30 April 2021

## Appendix A - Agency Submissions

5 SPORTS BLDG - NORTH ELEVATION - (section through drainage)
1:200

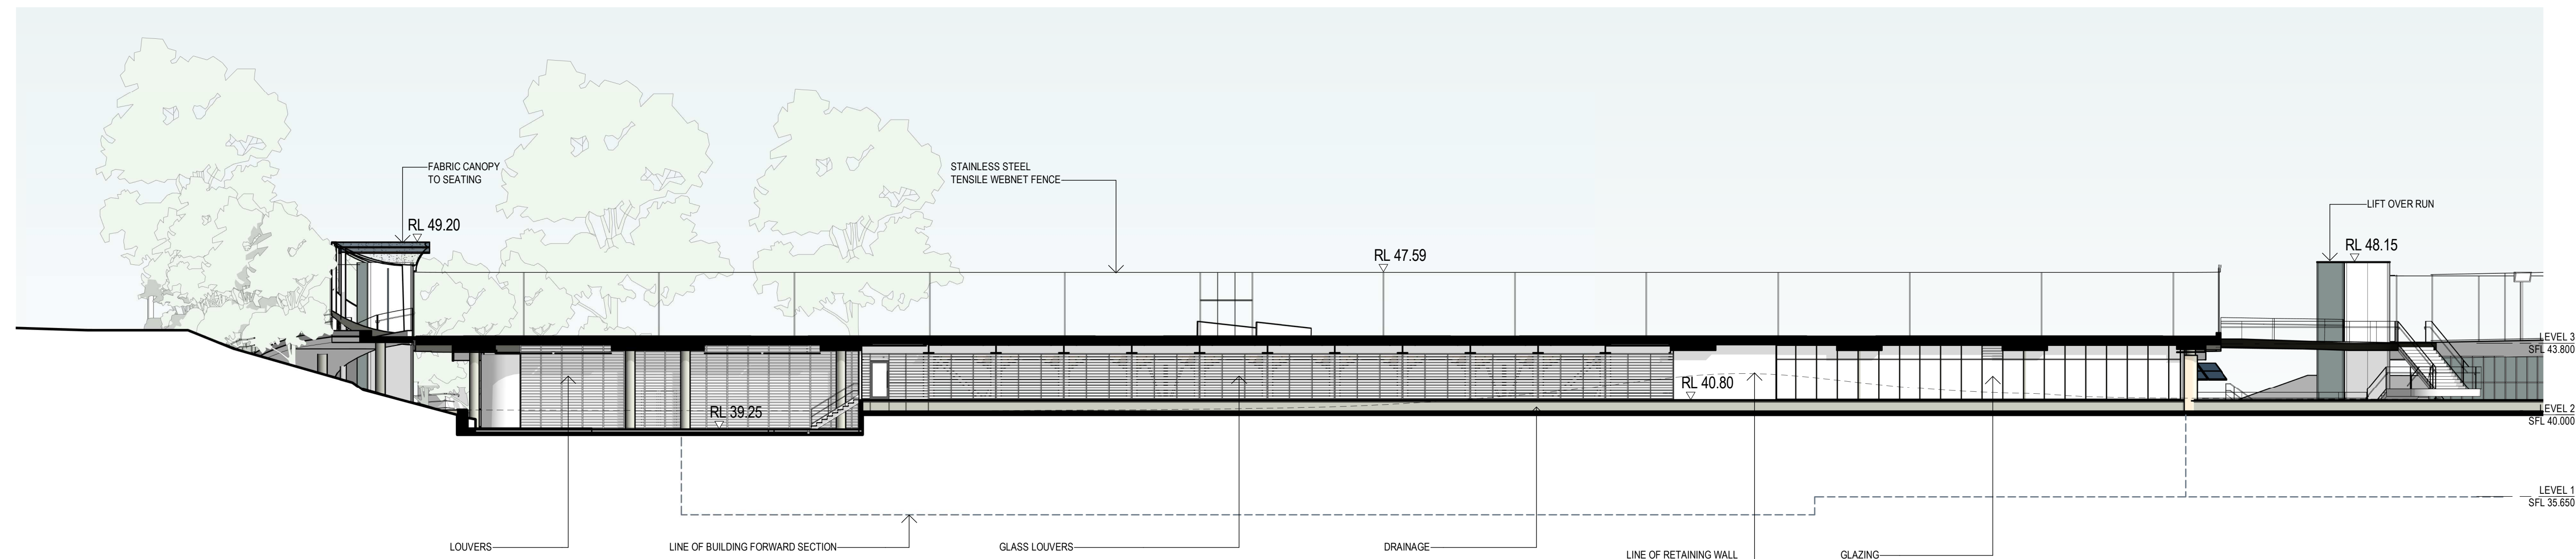
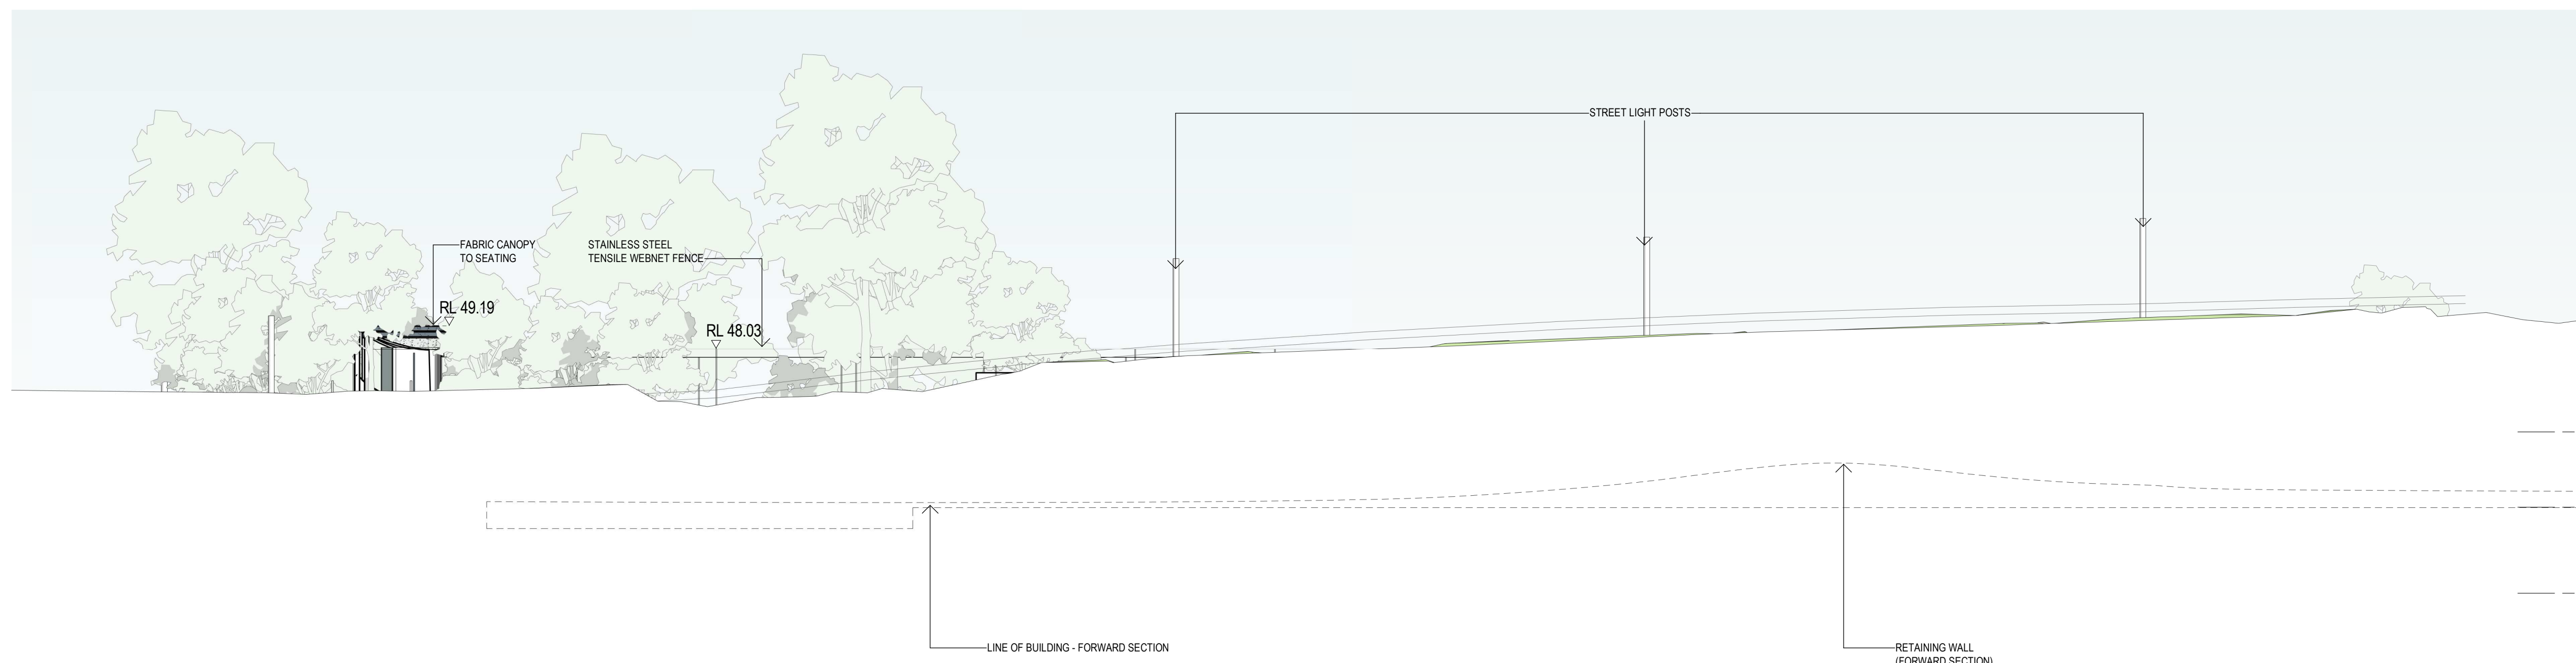
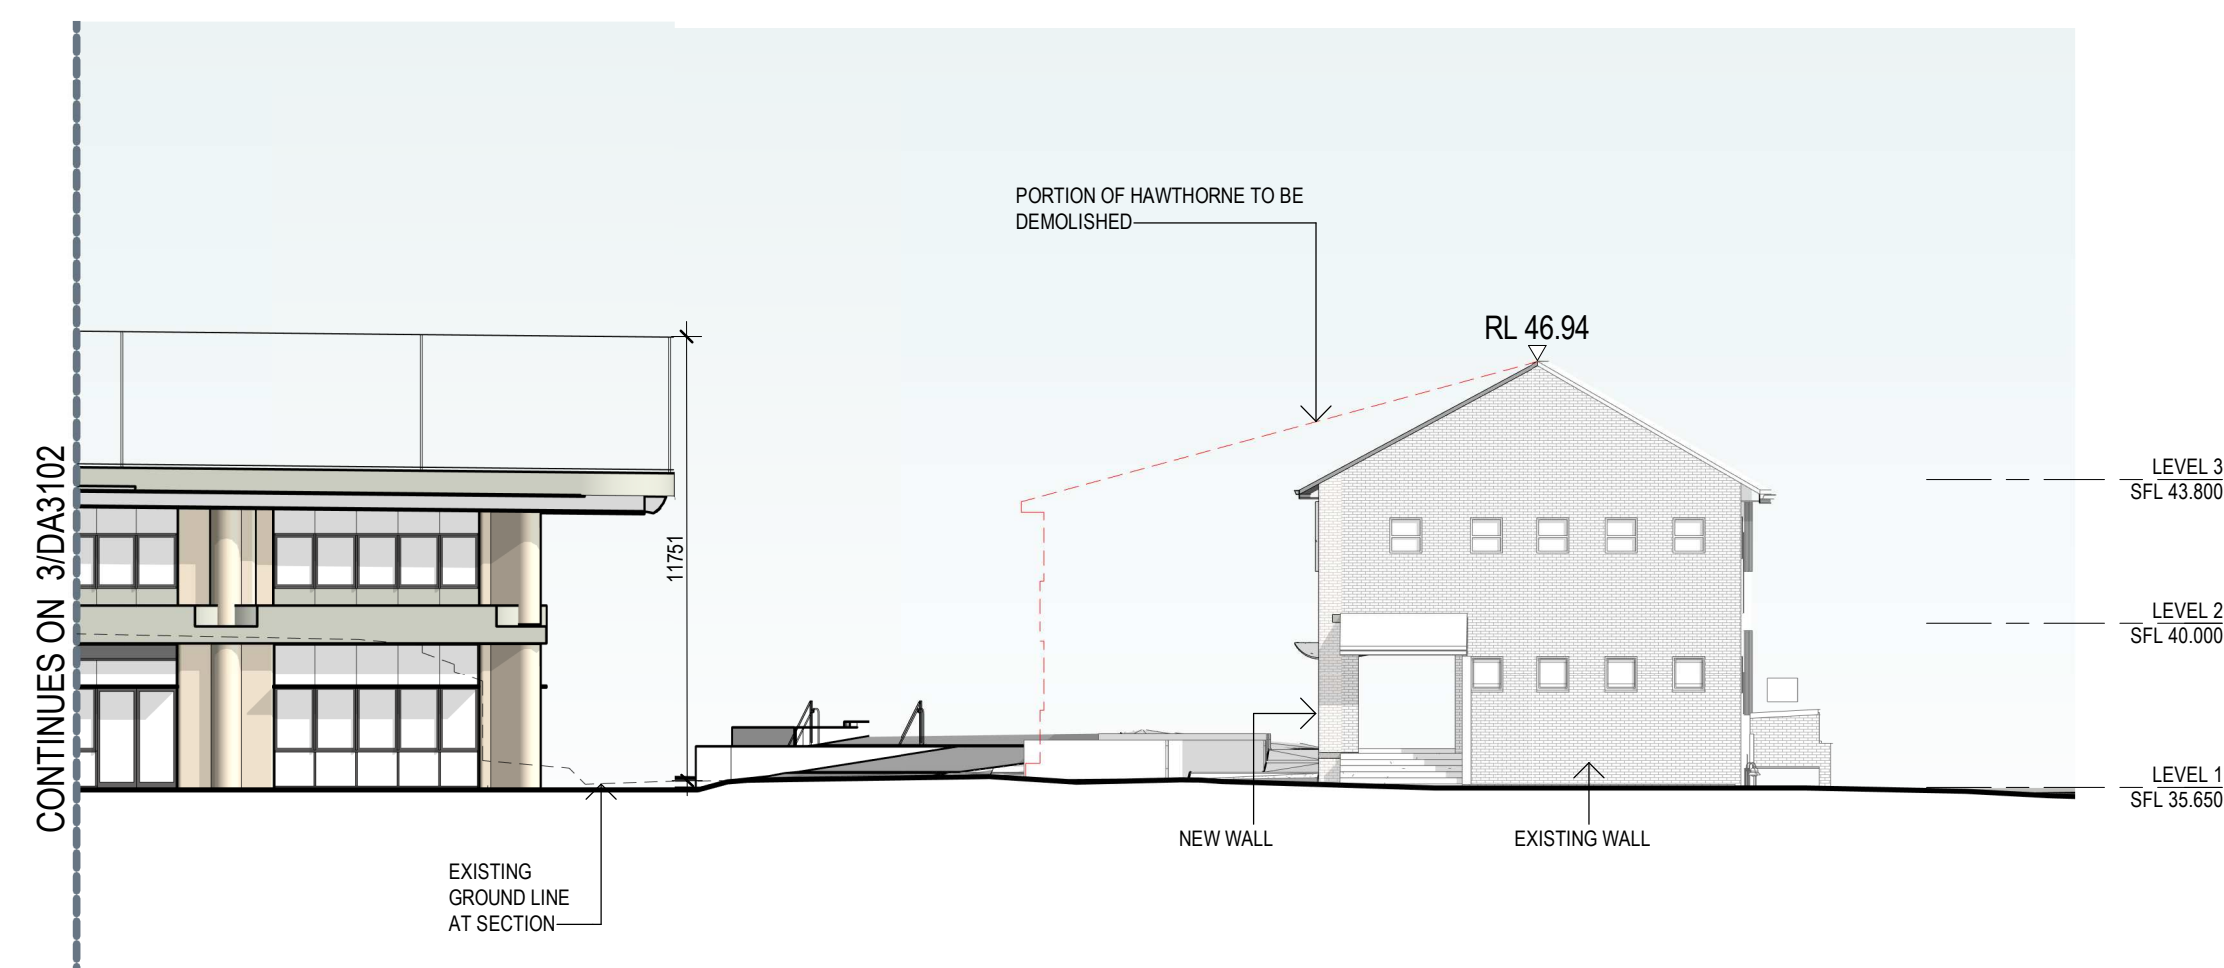
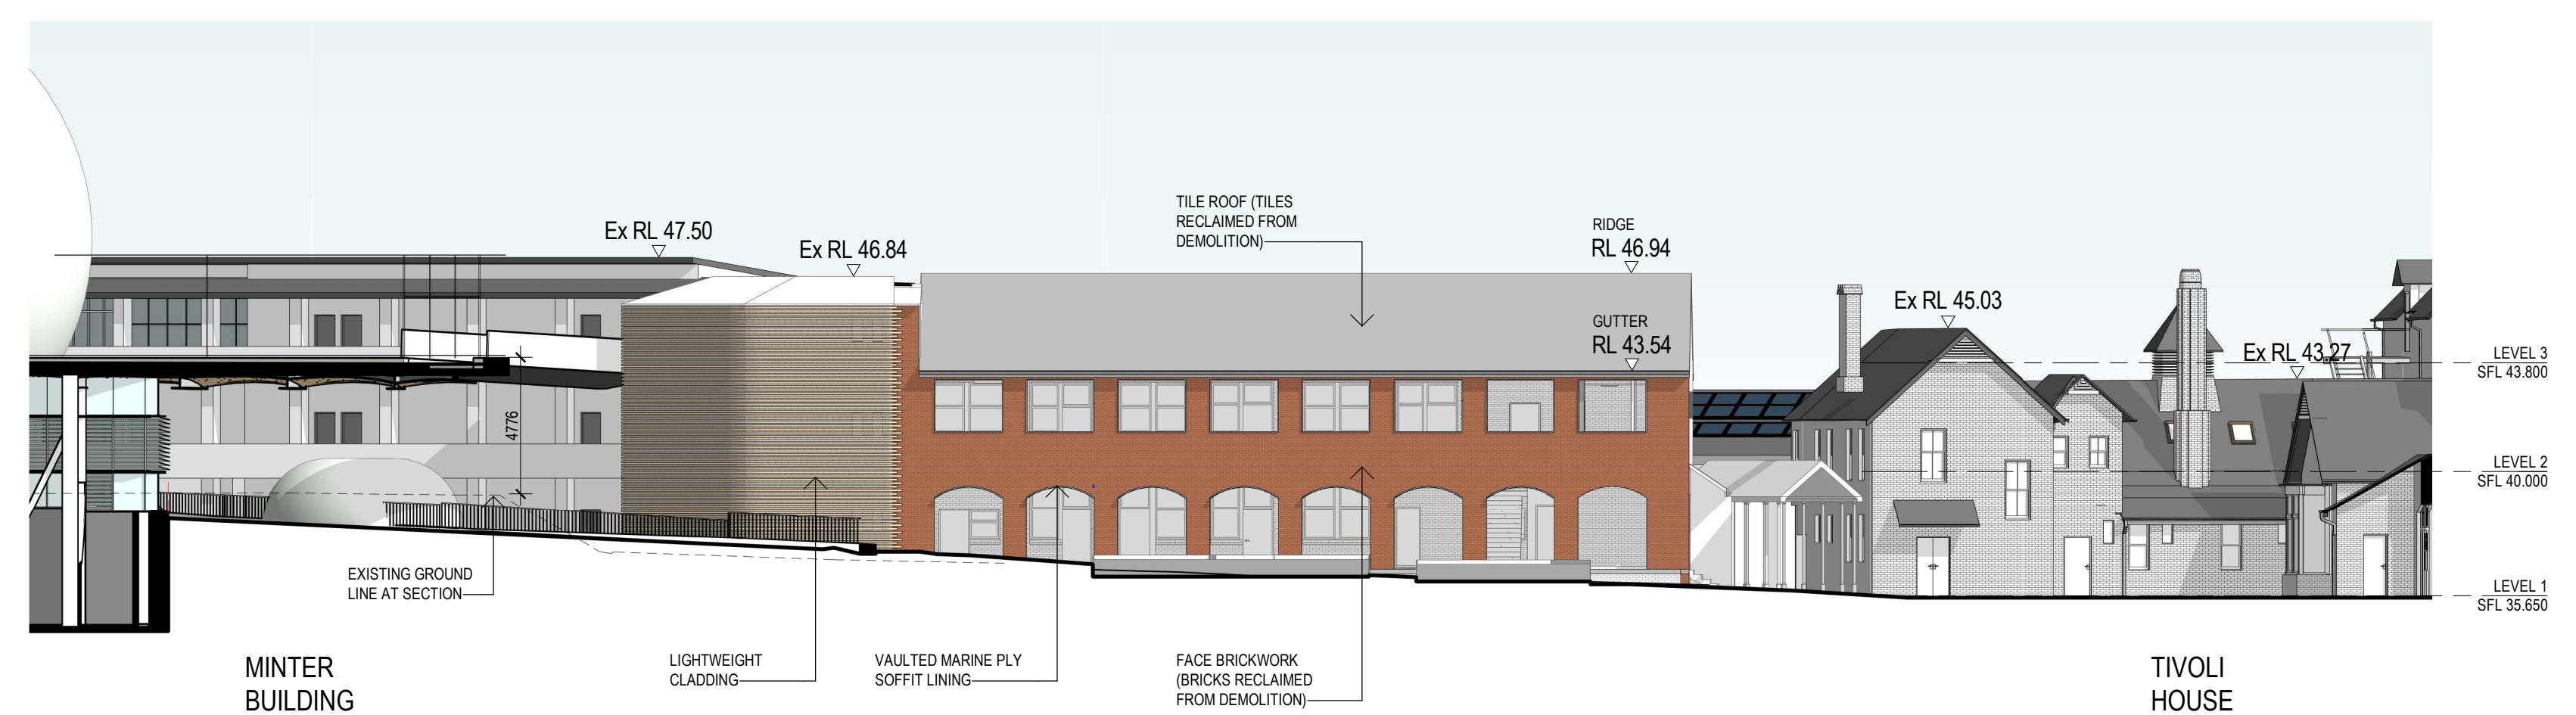
Summary of issue raised	Comment
	planted, which will significantly increase the existing canopy cover on site. This is a net increase of 17 trees.
<b>Plans and elevations</b>	
The architectural plans should be updated to indicate the height of all buildings and structures from the existing ground levels in addition to the relative levels (RLs) shown.	Updated elevations have been provided at <b>Appendix I</b> , which show the height of all buildings and structures from the existing ground level.
The submitted architectural plans include elevations with incomplete references. The RtS must include updated architectural plans with elevations of all facades of each of the new buildings proposed that are clearly labelled to include North, South, East and West.	Updated elevations have been provided at <b>Appendix I</b> have been prepared, which show elevations of all facades of the buildings.
<b>Landscape Plans</b>
